SITE 53 SYDNEY OLYMPIC PARK

SECTION 4.55 MODIFICATION (SSD 7662 Mod 1)

RESPONSES TO DPE COMMENTS

**GENERAL ARRANGEMENT
PLAN - LEVEL 03**

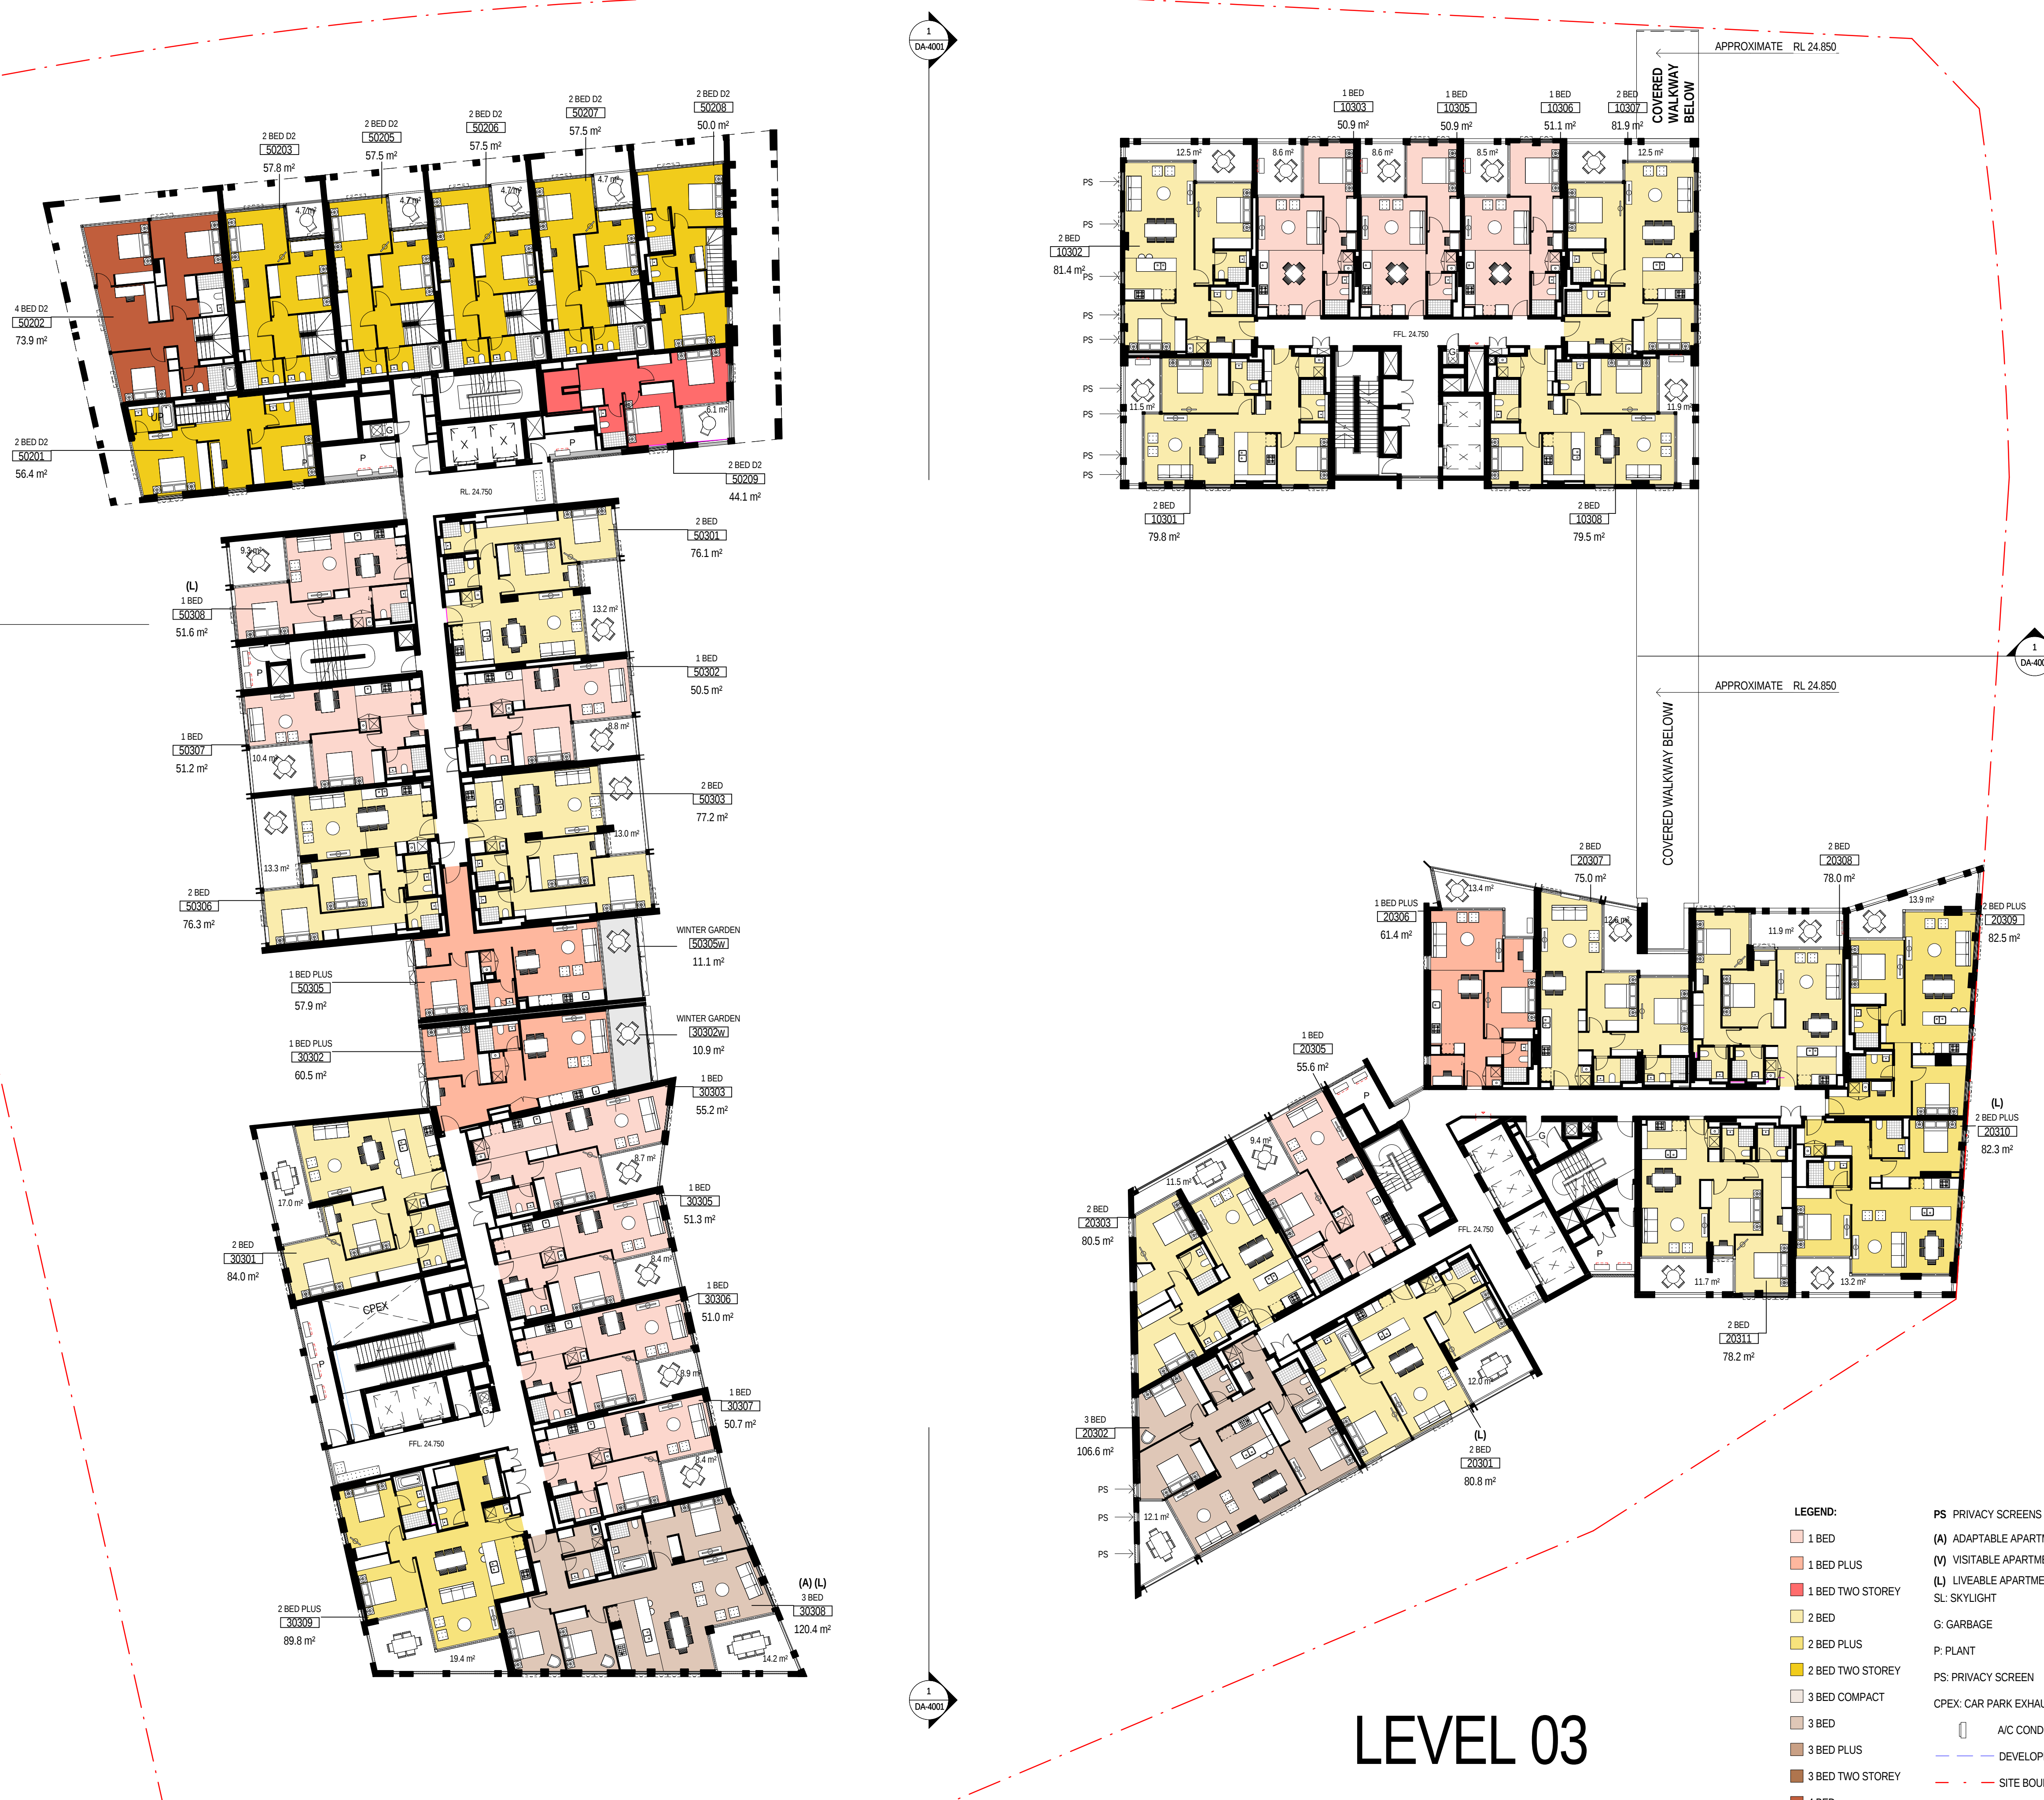
PROVIDE FURTHER INFORMATION AND JUSTIFICATION FOR THE PROPOSED RELOCATION OF THE PRIVACY SCREENS FROM THE WESTERN ELEVATION OF BUILDING 1 (LEVELS 3 TO 8) TO THE EASTERN ELEVATION OF BUILDING 5 (LEVELS 4 TO 8)

THE PROPOSED PRIVACY SCREENS ARE RELOCATED FROM THE LOW-RISE (BUILDING 1 – 12 STOREYS) TO HIGH-RISE BUILDING (BUILDING 5 – 23 STOREYS). THE PROPOSED AMENDMENT AVOIDS THE PRIVACY SCREENS DOMINATING OR OVERPOWERING THE FACADE OF THE LOWER-SCALE BUILDING 1. IT WORKS AS A TOOL TO VISUALLY REDUCE THE APPARENT MASS OF BUILDING 5 BY ARTICULATING ELEVATION TO CREATE INTERESTING PATTERNS OF SHADES AND SHADOW AND PROVIDES A BETTER SENSE OF SCALE AND PROPORTION.

AS SHOWN IN THE IMAGE, THE PROPOSED PRIVACY SCREENS CONTINUE THE 'BARCODING' CONCEPT WHICH IS PRESENTED IN MANY DIFFERENT CONTEXTS IN THE DEVELOPMENT. THE EXTENT OF PRIVACY SCREEN IS REDUCED FROM 5 TO 6 FLOOR LEVELS AFTER RELOCATION BUT MAINTAIN THE SAME PRIVACY PROTECTION TO THE APARTMENTS. DETAIL DESIGN WILL BE GUIDED BY THE BASIX REQUIREMENTS TO ENSURE THERMAL COMFORT IS MAINTAINED.
